January 29th 2020

I would like to address the comments made by yourself regarding Listed Building planning application BR/237/19/PL and BR/238/19/L relating to the Picturedrome Cinema, Canada Grove, Bognor Regis.

PROPOSED DOOR ELEVATION 1:20

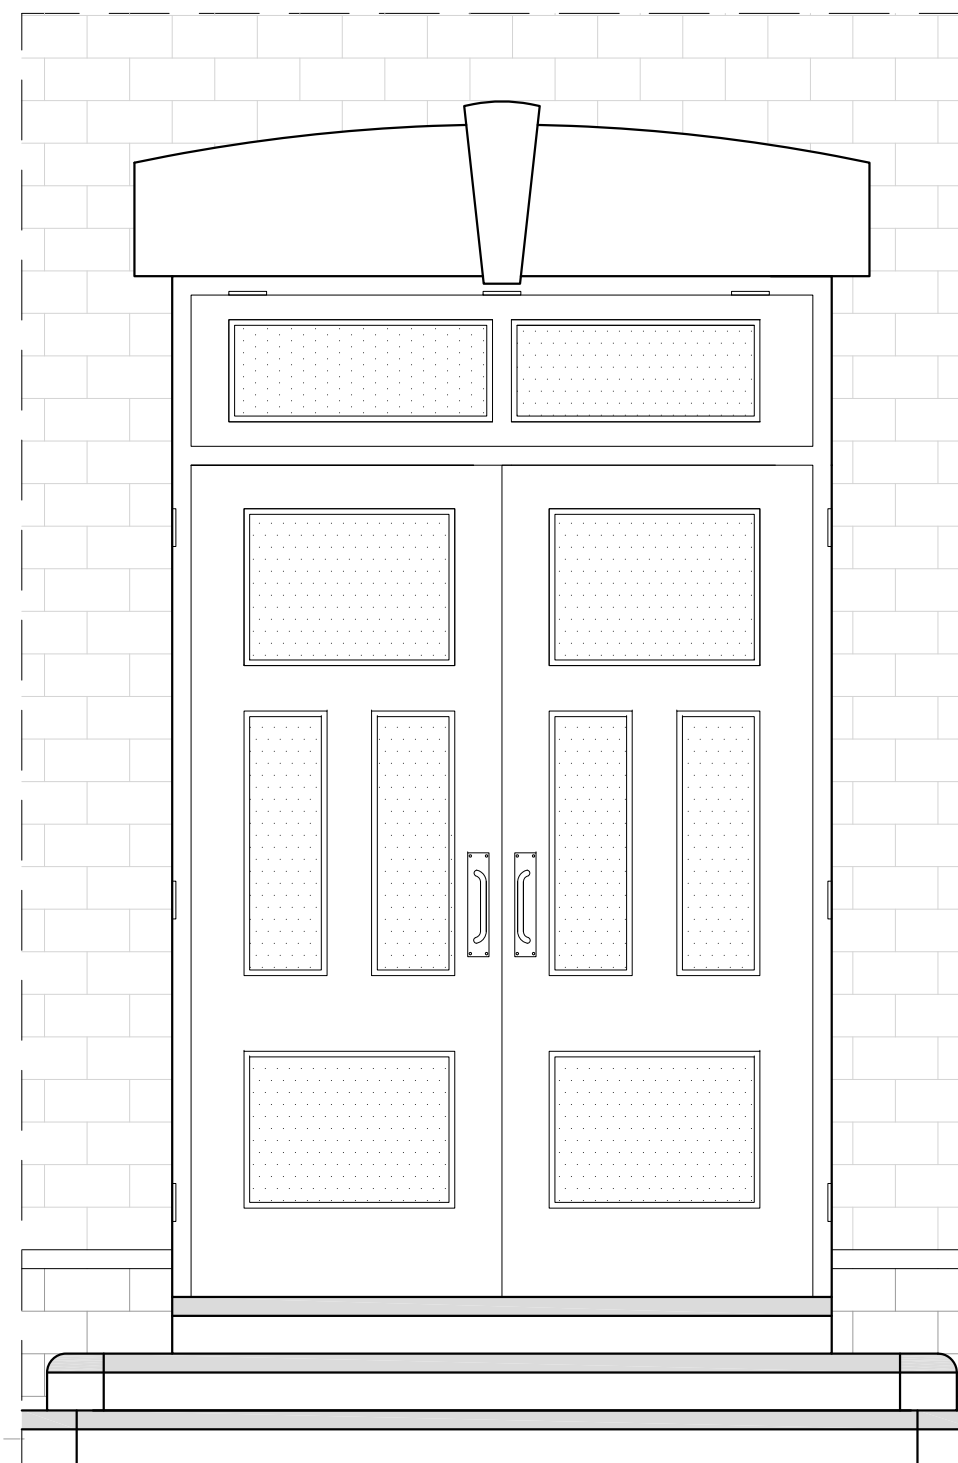
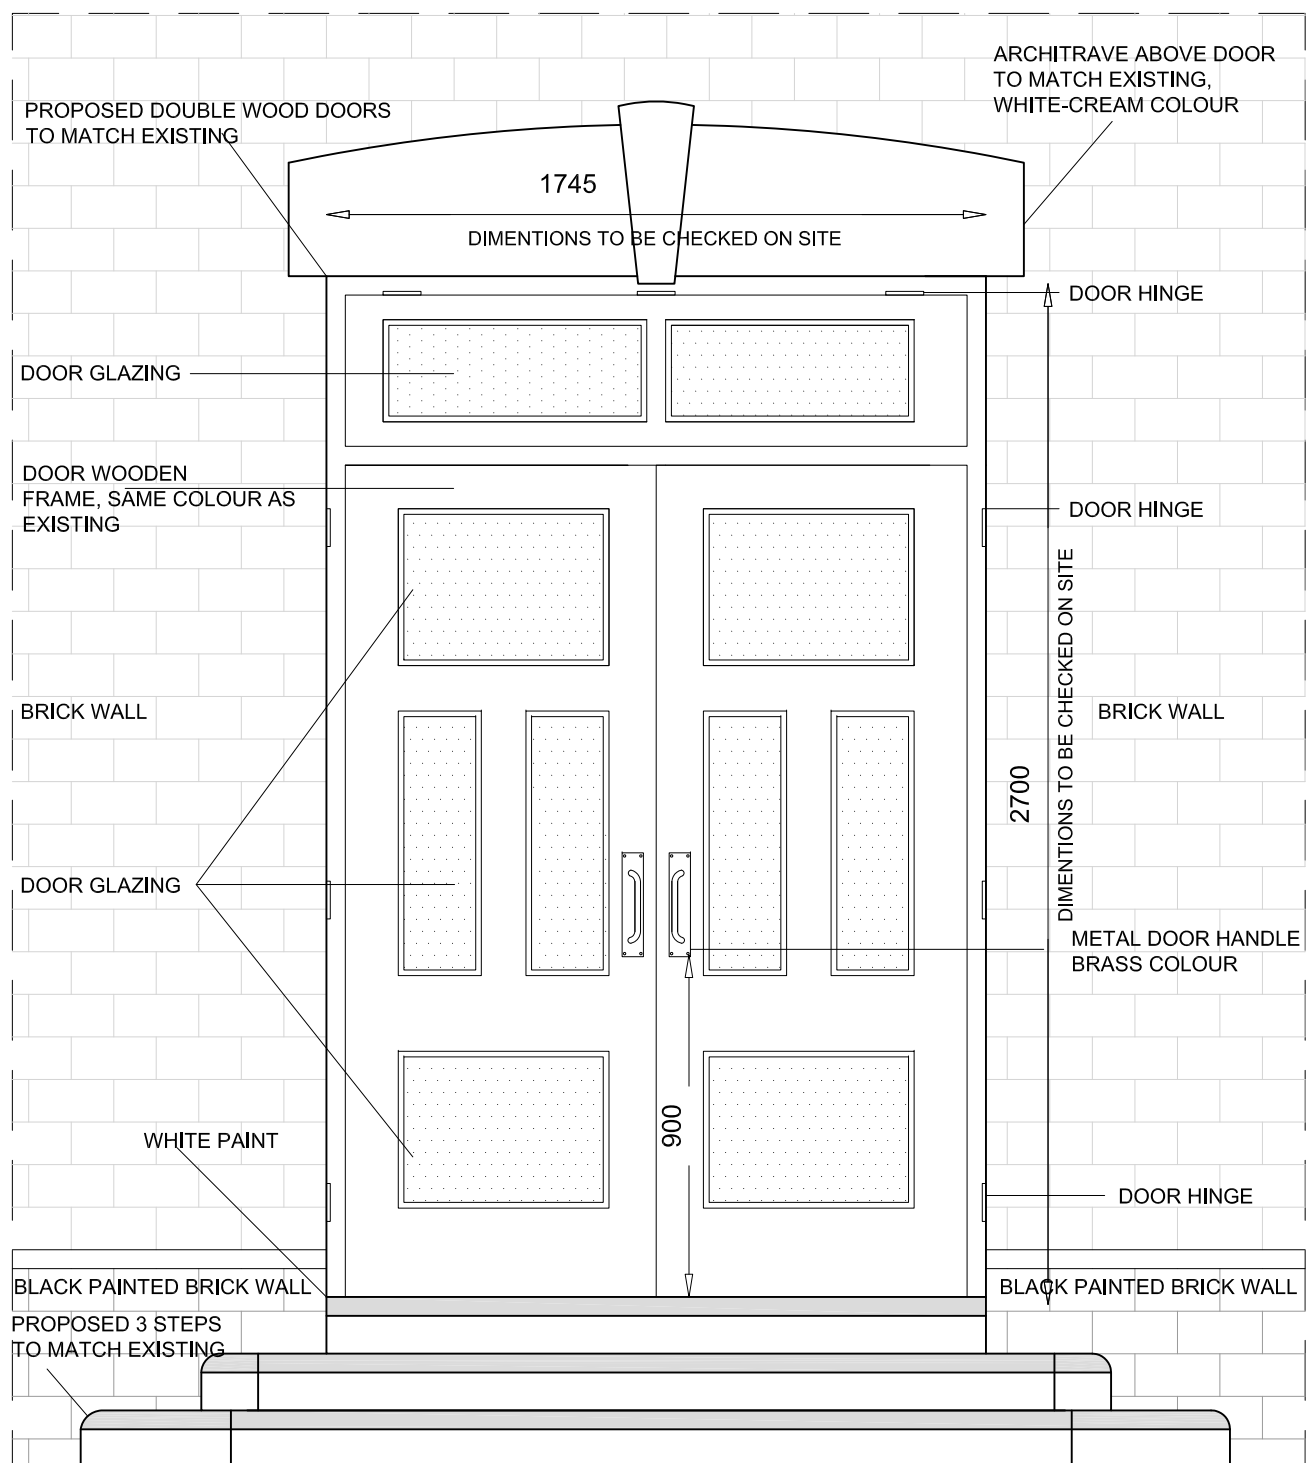
We strongly feel that the proposals will make the building sustainable for the future, yet not detract from its original features, since what we are planning is far closer to the original plans than what is there currently. The proposal to put the door back on the front is only to return an original feature- since that was how it was historically- it is not an essential part of what we are trying to achieve, though it would certainly be an improvement to the layout and look of the foyer, and is desirable. The plan to change the space on the first floor, is simply to enhance and facilitate the opening up of the office below, which is the main purpose of this application.

PART OF GROUND FLOOR PLAN

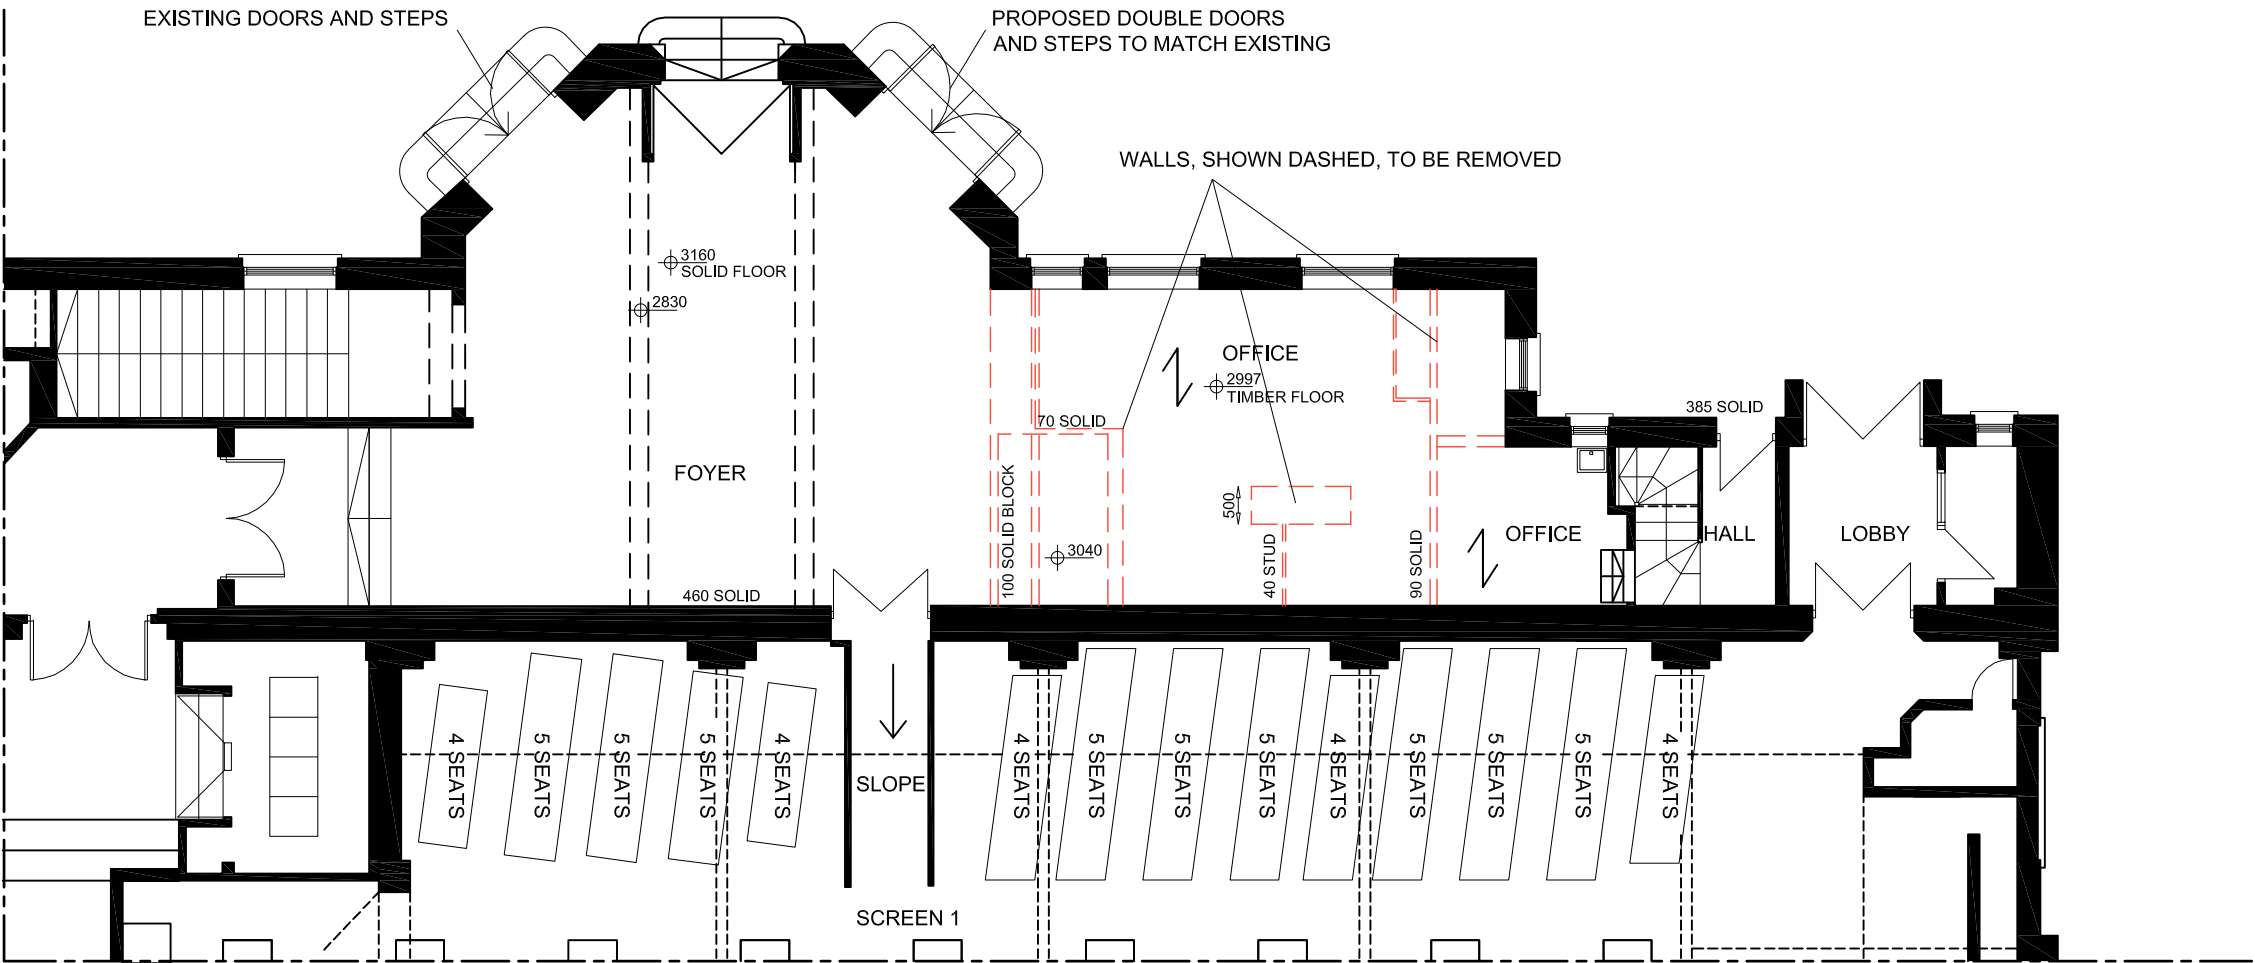
You mention your concerns about the loss of internal walls on the ground floor, which you feel would erode the character of the space, and thus impact upon the significance of the building. The reason for opening up the office, and moving the kiosk back, is to make the whole foyer space far more flexible and usable- and would in fact return it very much to how it was before, when it historically had a much larger vestibule area now, as the wall that we wish to remove was a later addition and so, in removing it, we are in fact, returning it more closely to its' original layout.

With regard to long term conservation of the building and, in order to retain it as a viable and thriving cinema, we must keep up with current trends, and recognise opportunities and weaknesses. We are very confident that by opening up the office space as proposed and moving the kiosk back, we would create an attractive, light and airy space for our customers to queue more comfortably, purchase their tickets, and be offered a much wider range of concessions, in a vastly improved area, and we would thus be in a far stronger position to safeguard the buildings' future as a working cinema and a heritage asset.
